5/21/2018

It is our understanding Planning Staff has identified six deviations the current as-built 30 Merrill project has from elevations approved during the Site Application process:

Tom Landry - Managing Partner Banner Properties

**4 ROOF PLAN**  
 SCALE: 1/4" = 1'-0"

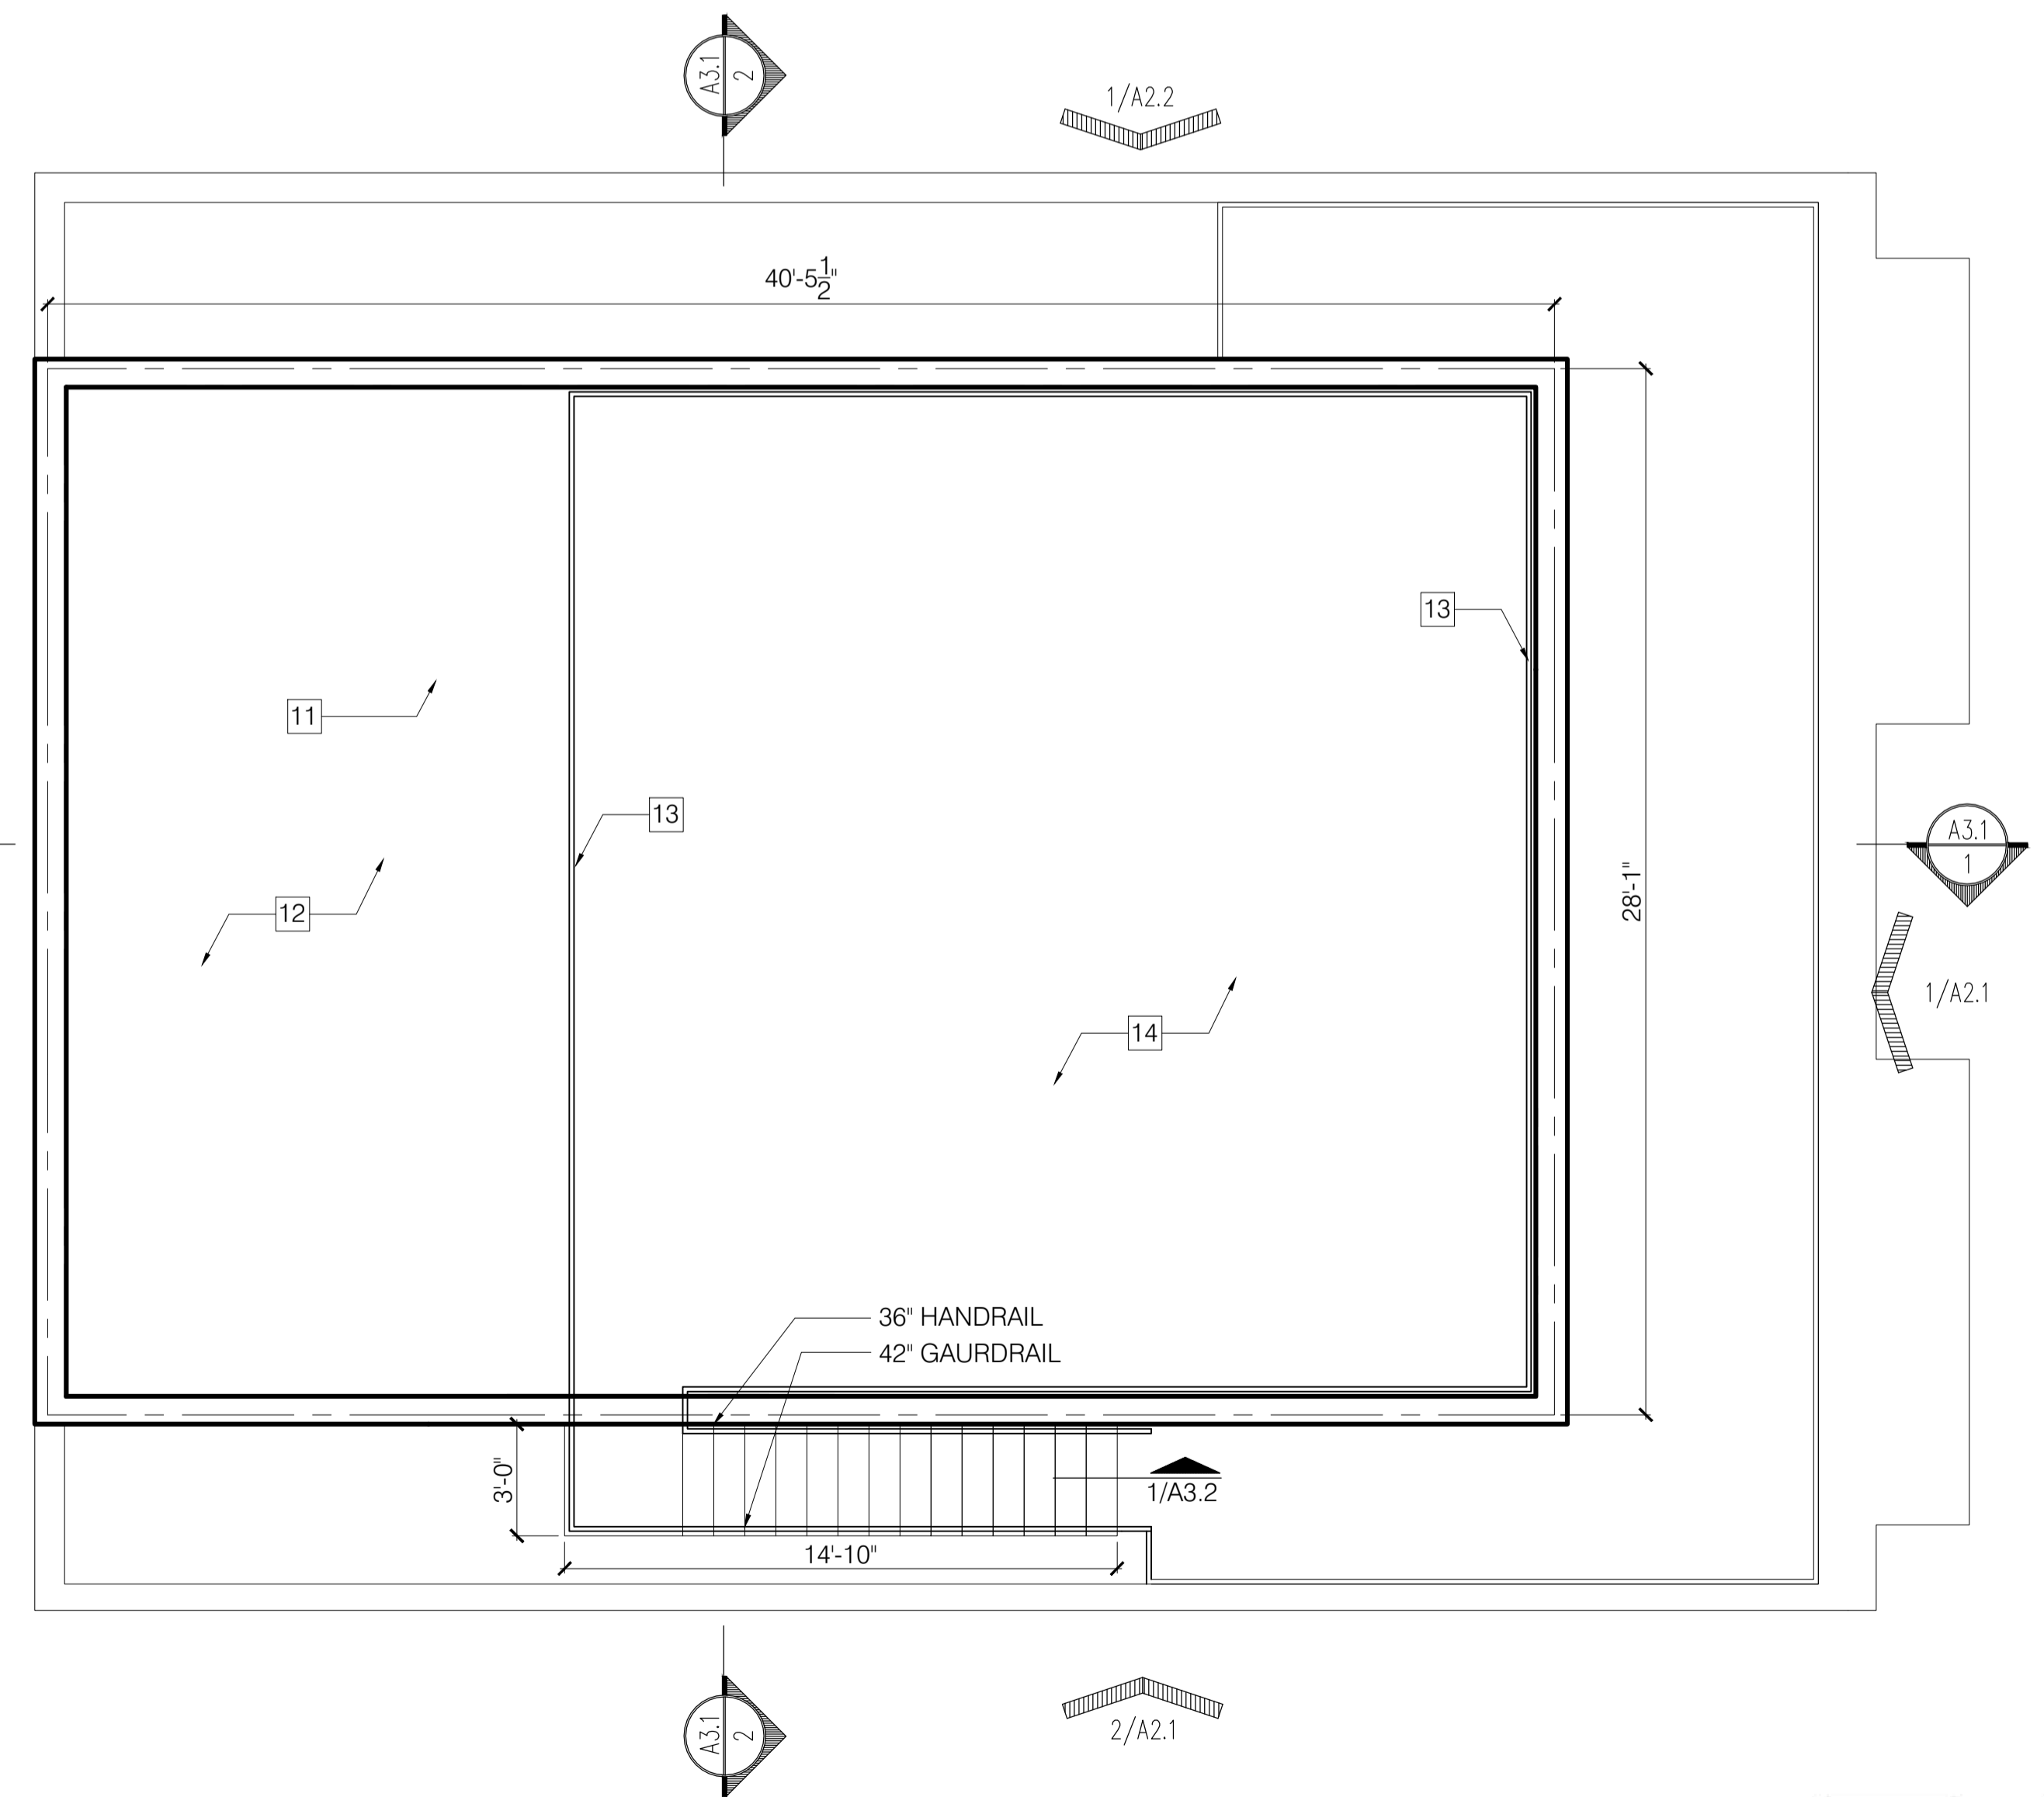
- Balcony railings were constructed with black metal posts.
- Balcony railings follow the perimeter of the bays on the front of the building.
- Missing green screen
- Lack of vertical siding behind the green screen.
- Loss of the break metal trim detail between the windows on the bays
- Dark color on the cornice of on the fourth story.

- Paint the balcony railing post on both roof levels, including the posts on the stairs, a lighter color. This could be a color that matches the railings (more of a silver that blends with the sky (can't get much more recessive then that) or maybe white. Open to input of course.

- Keep the railings and posts in their current locations. We re-examined the submitted plans in detail and from all angles. The design or more if the rails/post 'contour' the roof in all areas is unclear. This is where an aerial view looking down at the roof would have been helpful and left no room for interpretation or ambiguity. Short of this the contractor made a call we fully approved and supported - to have these follow the roof line in all areas. This uniform approach just seemed to make sense and again fits with what we feel is a logical interpretation of the plans. We can see where the other interpretation could arise and this is a point we will ask for from Bild or others in the future.
